Application No: FP/3/25/HH
Site Address: 7 Second Avenue Felpham PO22 7LJ
Description of works: Proposed timber shed and front garden fence.

Thank you for your internet representation made on 5th February 2025 which has been recorded as no objection with the comments as follows:

Drawing:
**Shed
Plan As Existing & Proposed**

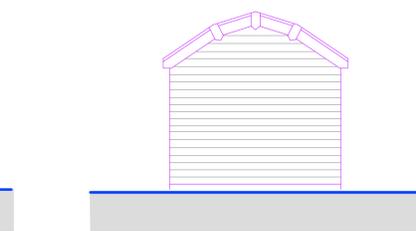
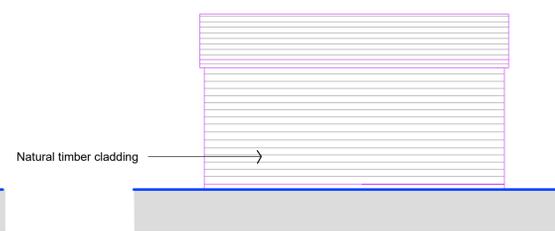
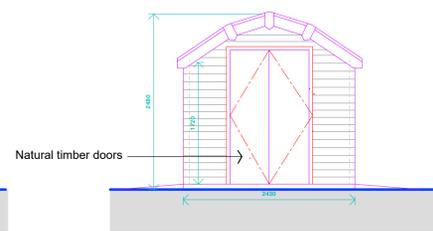
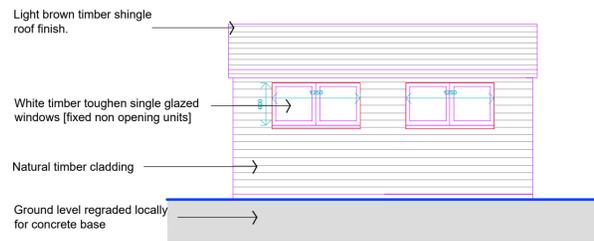
Note: Inadequate information regarding location and height of fence which appears to be higher than 2m
Inadequate biodiversity statement
